West Burton Solar Project

Land Plan Revision ~~A~~B - Change Application Version (Tracked)

PINS reference: EN010132

Document reference: ~~APPCR1~~/WB2.2_ ~~A~~B

Land Plans
 Sheet 6 of 10
 Revision A

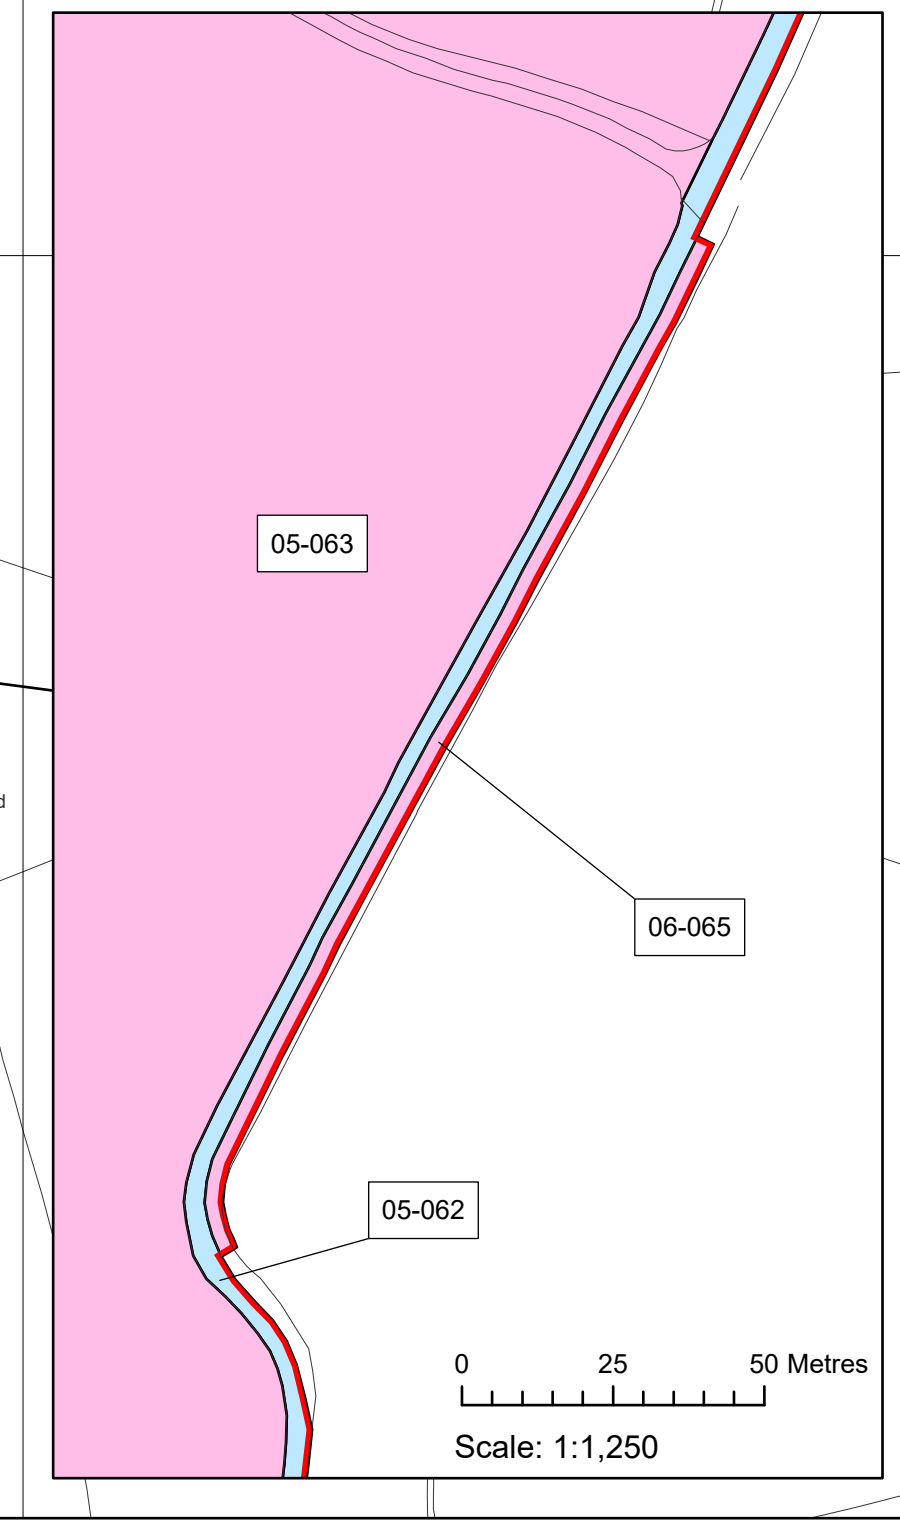
Sheet 6 of 10	10	New plots added	Changes in the Red Line Boundary have created plots 06-072a, 06-072b, 06-072c, 06-072d, 06-073a, 06-073b, 06-074a
Sheet 6 of 10	10	Update to the list of plots in the key on Sheet 6	Updated to reflect addition of new plots 06-072a, 06-072b, 06-072c, 06-072d, 06-073a, 06-073b, 06-074a

Land Plans
 Sheet 9 of 10
 Revision A

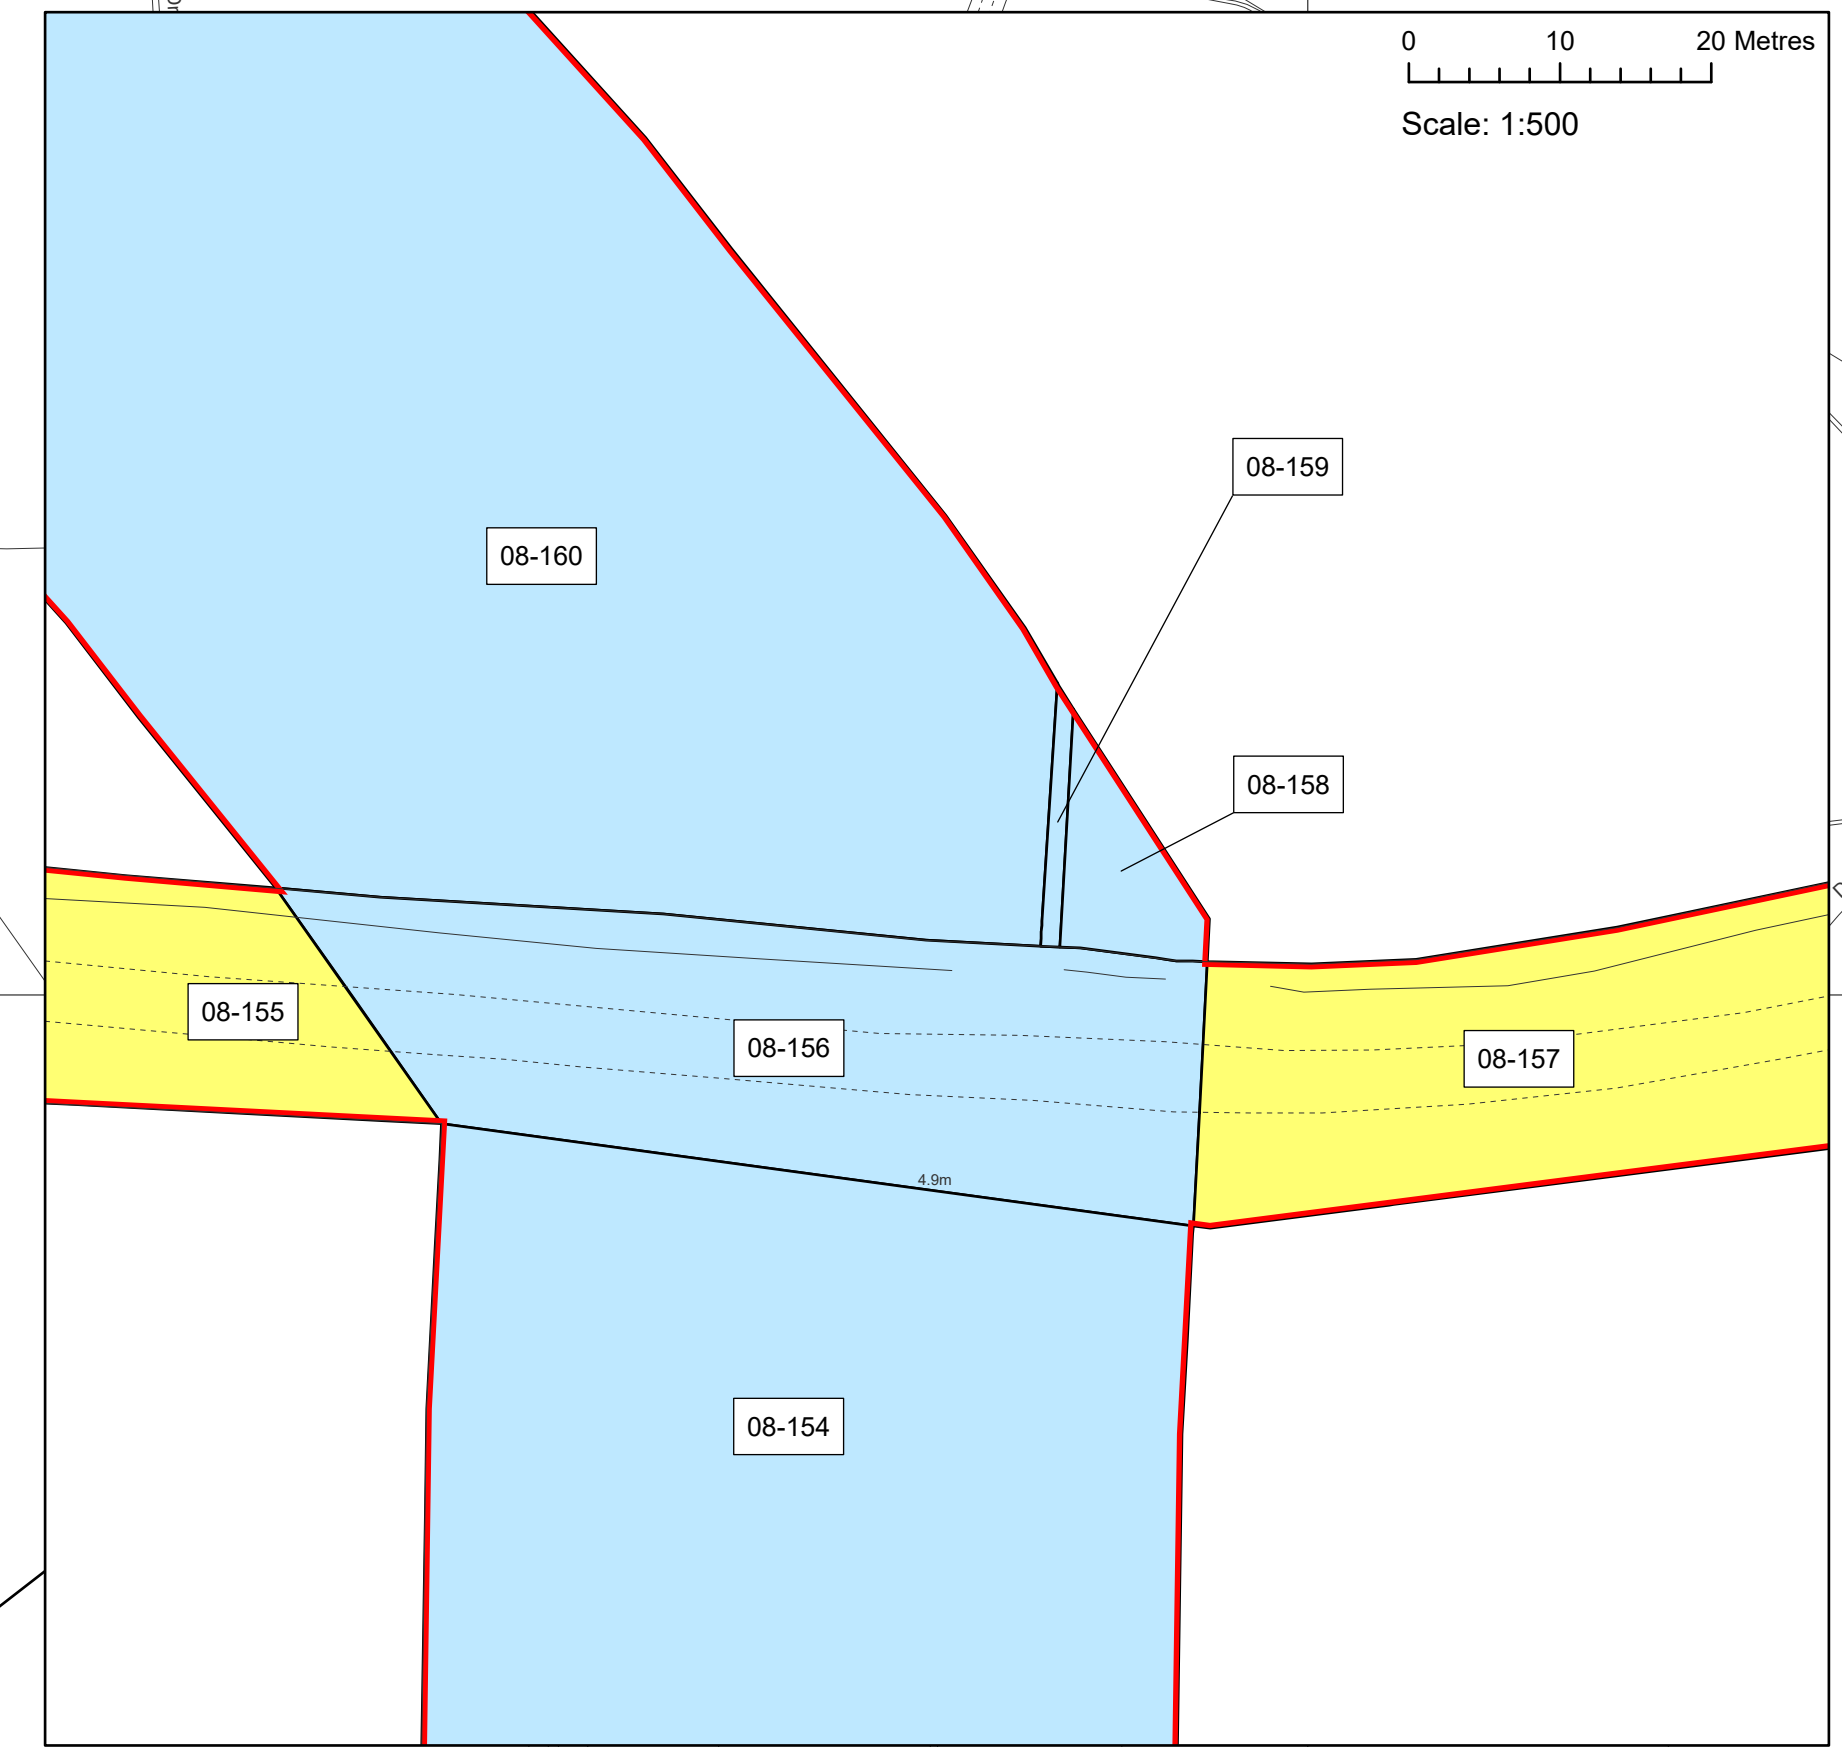
Figure Reference	Page	Description of Changes	Reason for Revision
Sheet 10 of 10	14	New plots added	Changes in the Red Line Boundary have created plots 10-183a, 10-183b, 10-183c, 10-183d, 10-194a
Sheet 10 of 10	14	Update to the list of plots in the key on Sheet 10	Updated to reflect addition of new plots 10-183a, 10-183b, 10-183c, 10-183d, 10-194a
